**WEST SUSSEX COUNTY COUNCIL
STRATEGIC PLANNING CONSULTATION**

SUBJECT: BE/91/13-Erection of 1 x four-bedroom detached bungalow.

Land north of, 258 & 260, Chichester Road, North Bersted, Bognor Regis, West Sussex, PO21 5AX

PLAN VIEW - EXISTING ACCESS SITUATION.

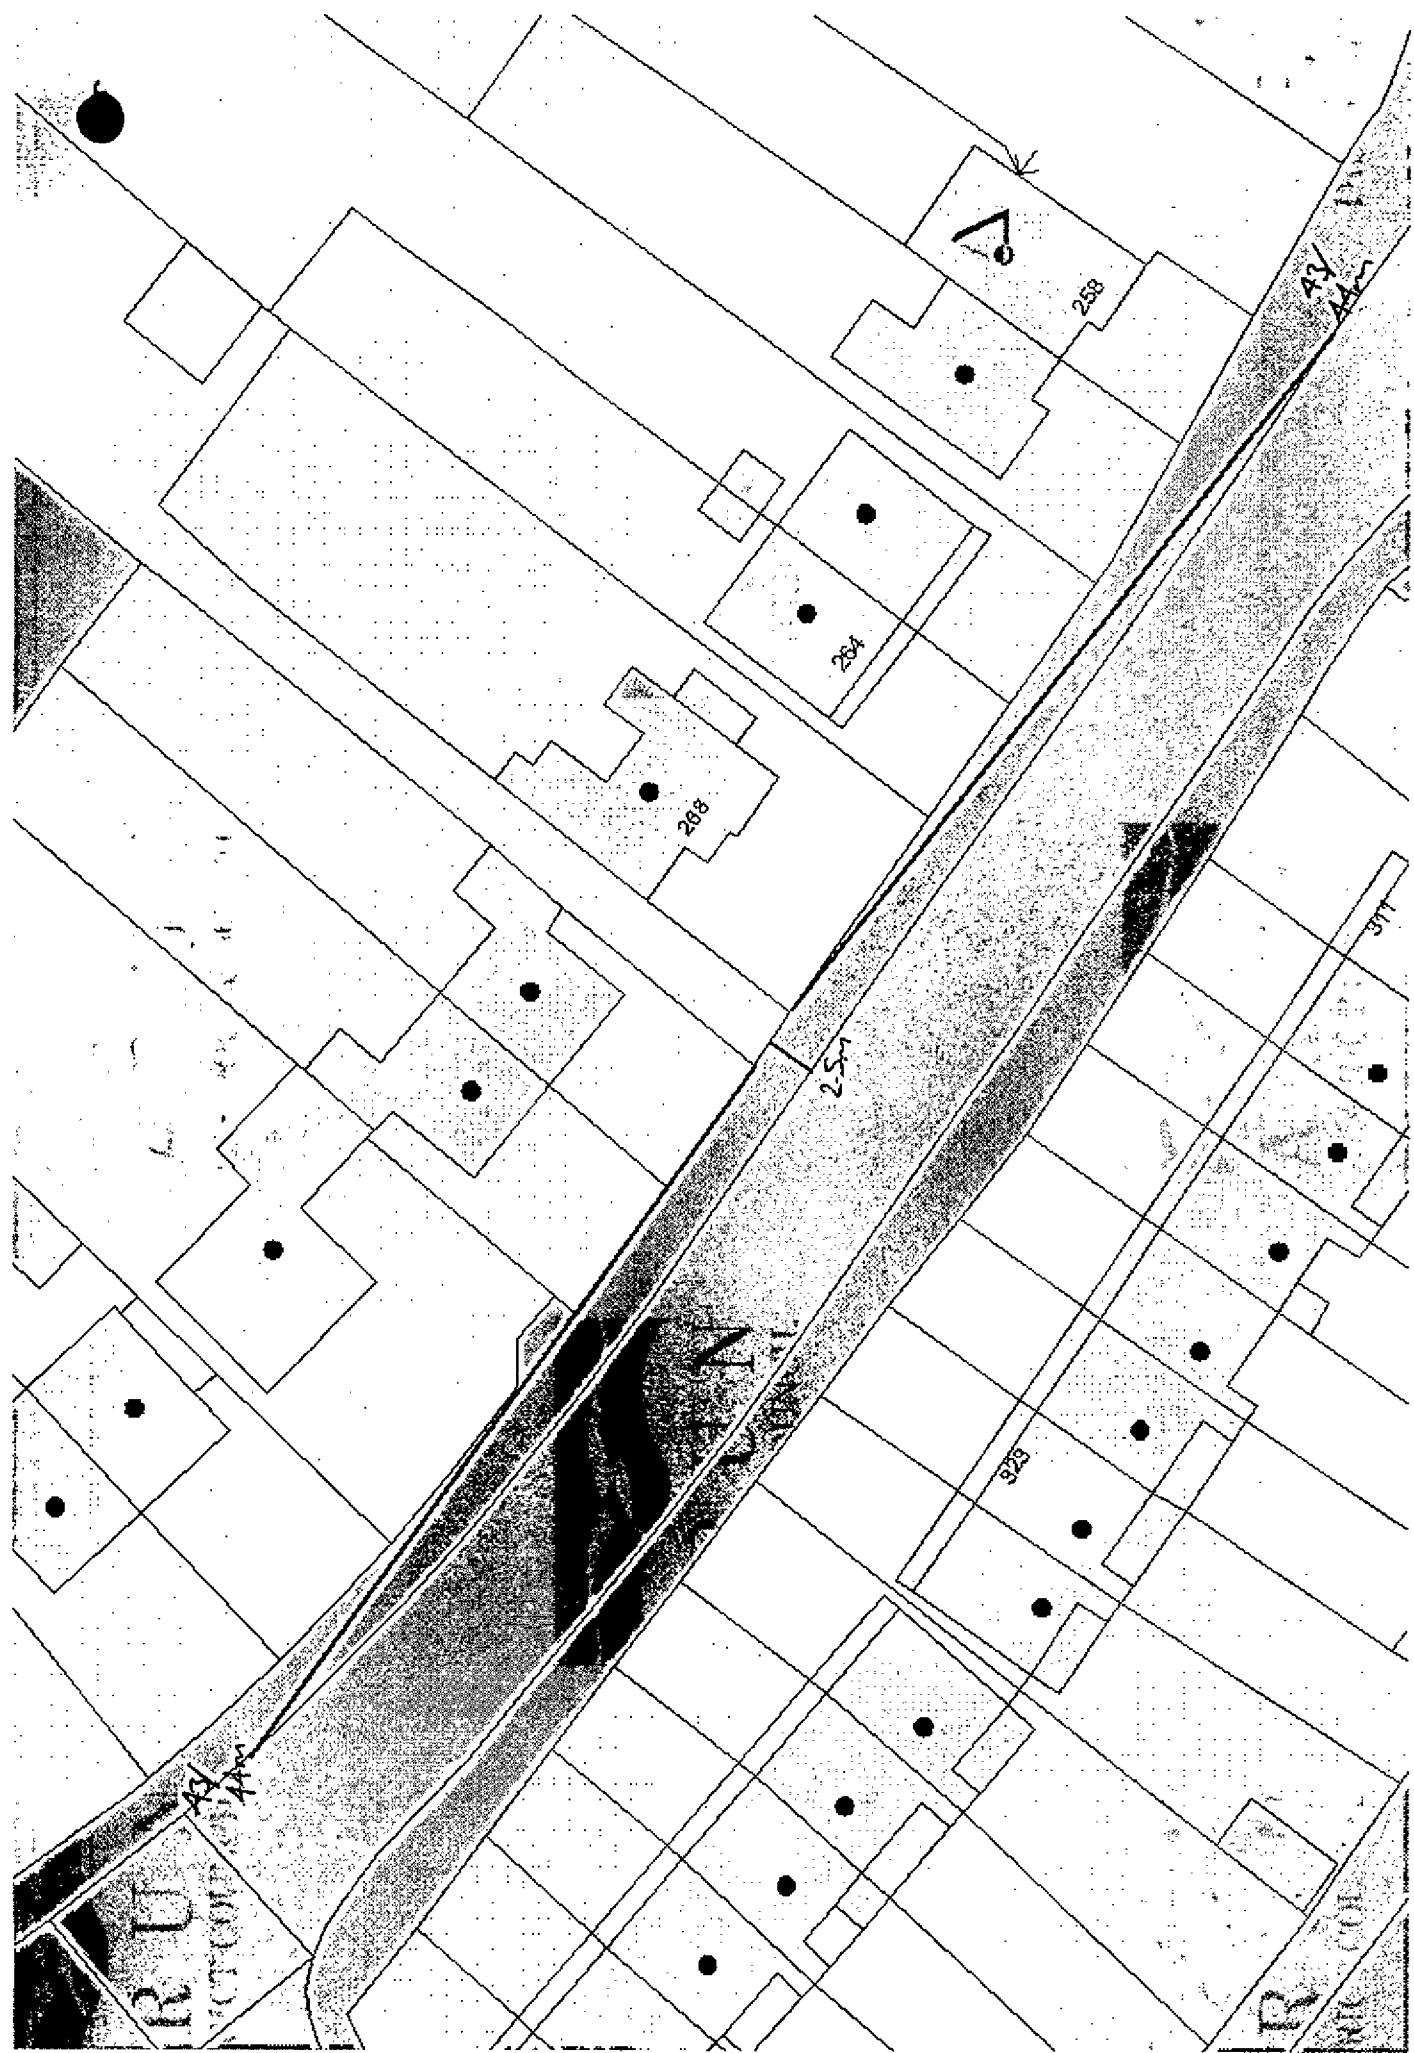
This proposal will utilise a shared access onto the A259 (Chichester Road). From inspection of the plans, there appears to be no apparent visibility issue at the point of access onto Chichester Road. However I would request the applicant provides a further plan showing available visibility splays at the new point of access, in line with the guidance set out within Manual for Streets for a 30 mph road which is 43 metres.

If the LPA are minded to approve this application a condition securing parking and visibility splays of 2.4 by 43 metres should be included.

DRAWING TITLE			
Proposed Housing Development Plot B off Chichester Road Proposed Site, Block & Location Plan			
DATE	SCALE	DRAWN BY	EC
Sept '13	as indicated	CHECKED BY	mf
JOB NO.	DRAWING NO.	REVISION	
1313	2.06

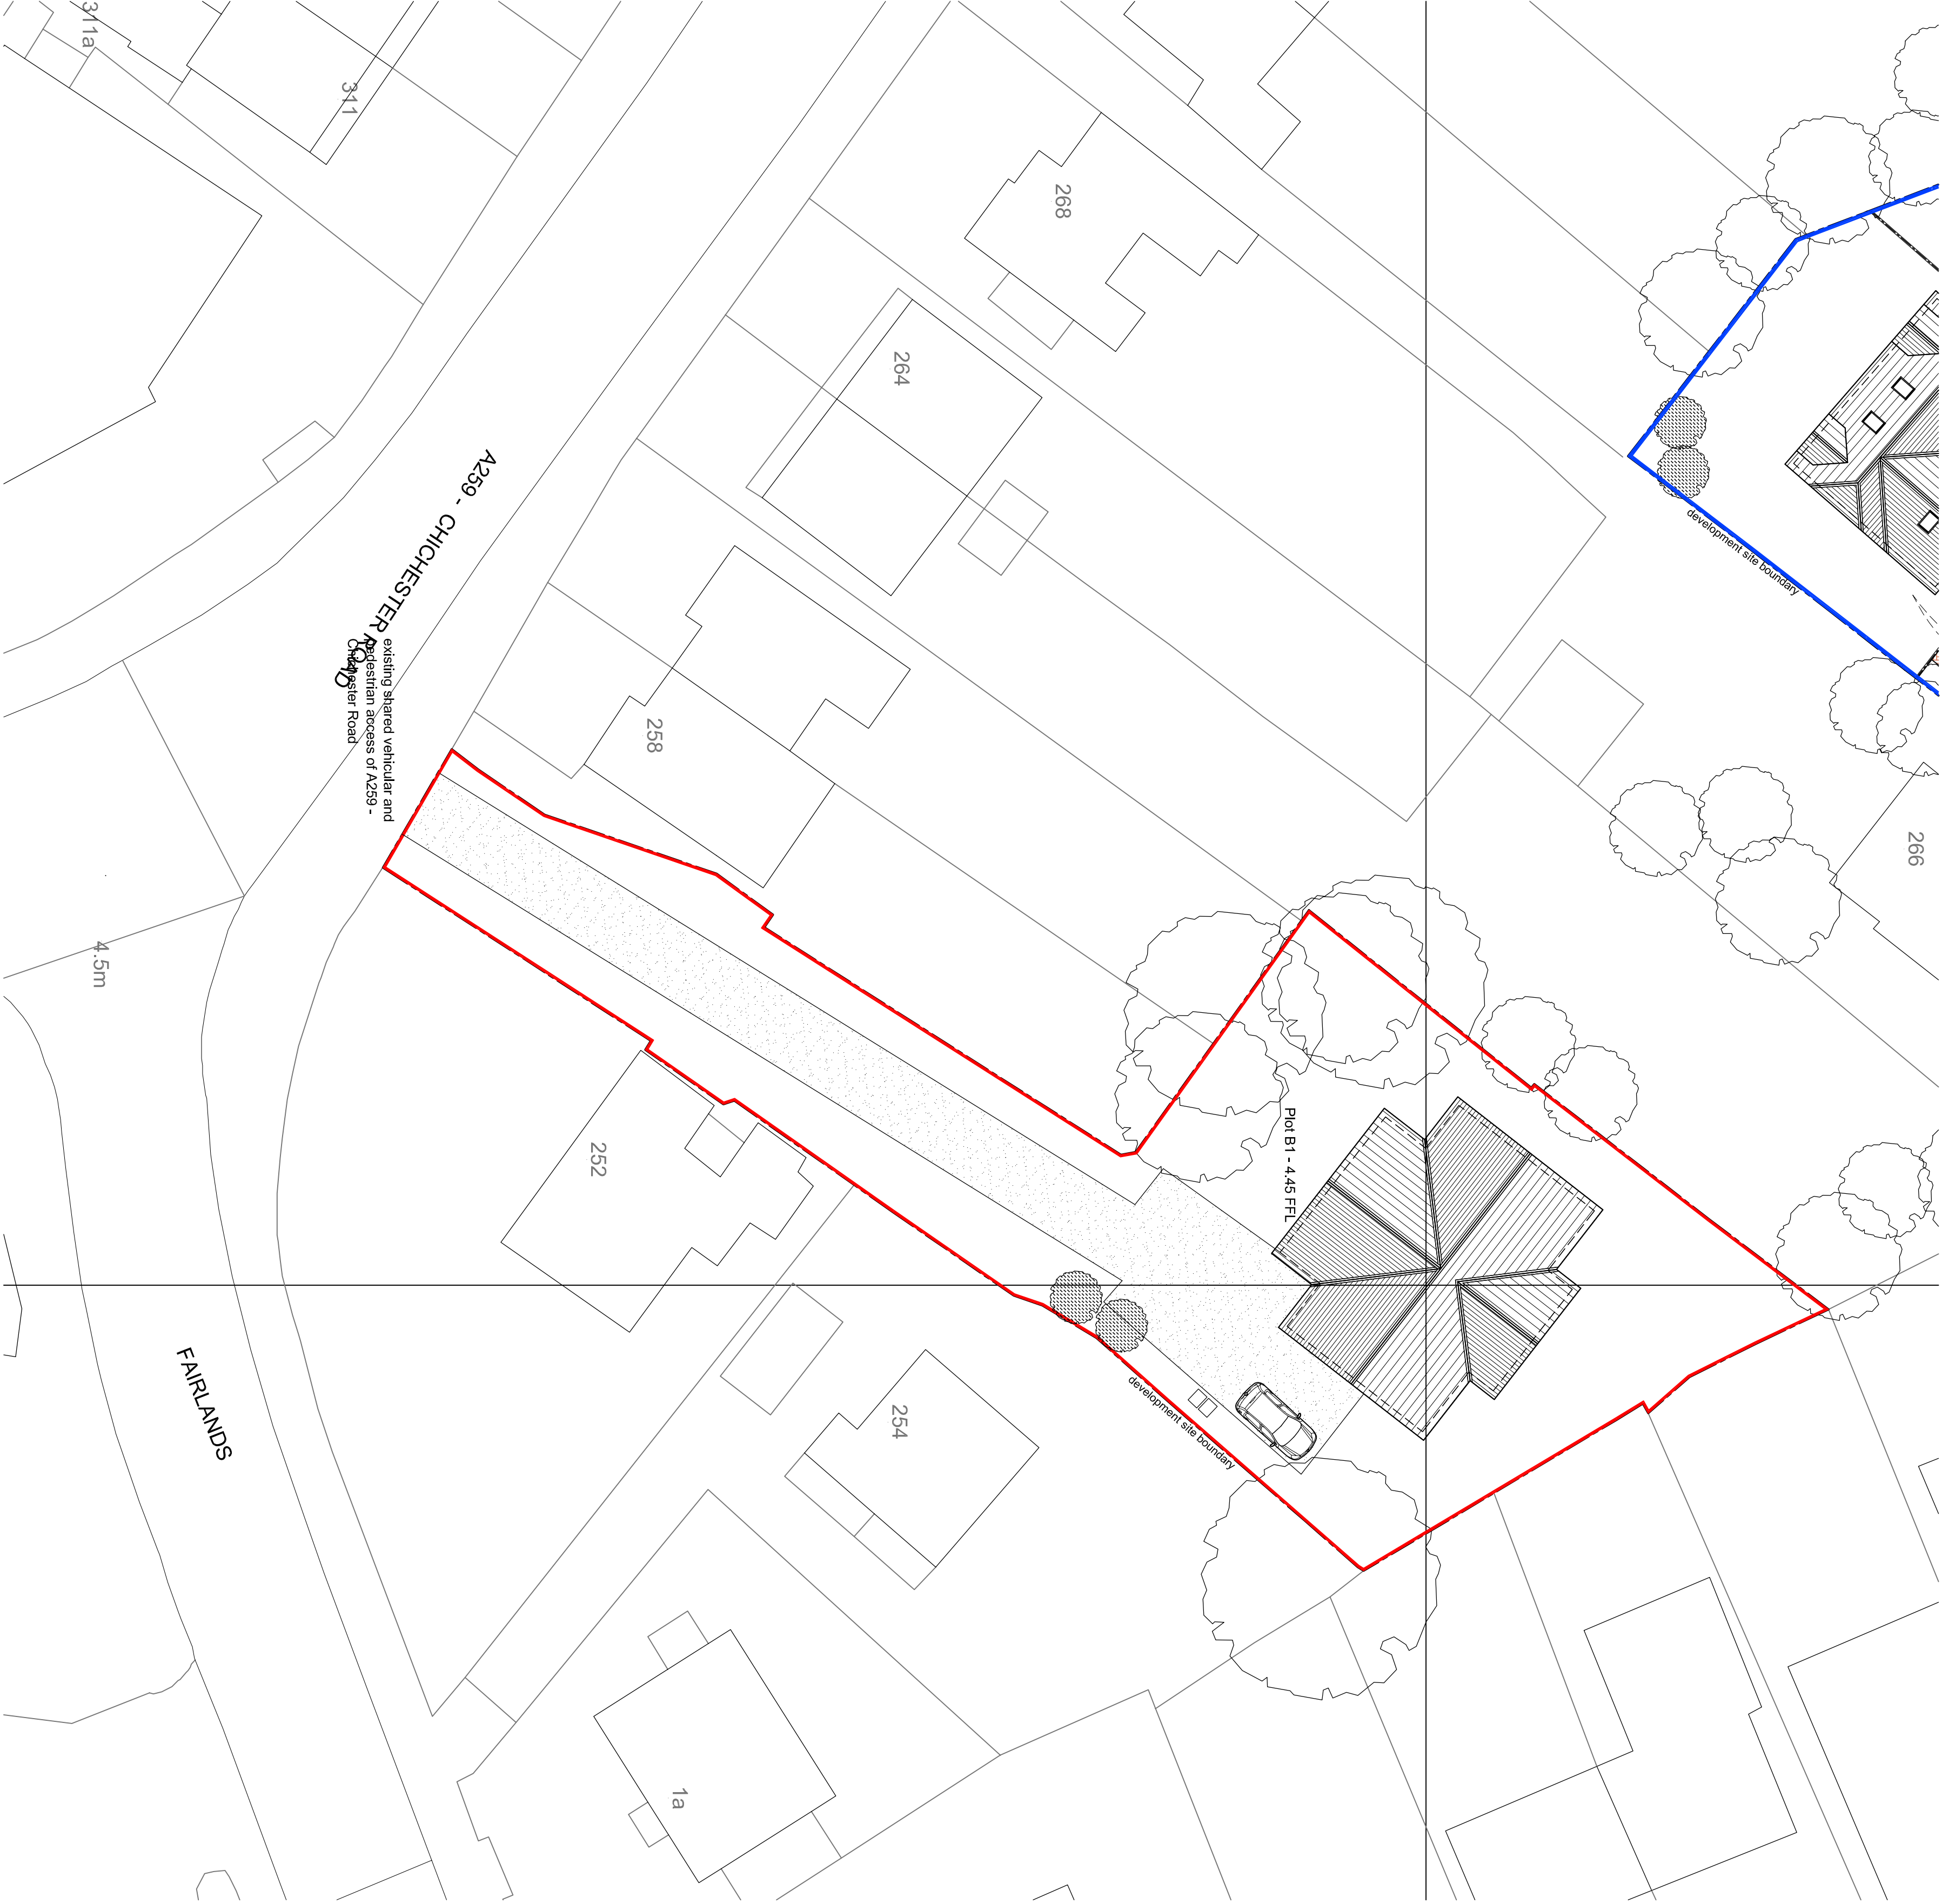
In terms of parking the proposed development does fall within the latest WSCC car parking standards. In terms of parking layout there would appear to be an adequate area of hardstanding available within the site to permit turning.
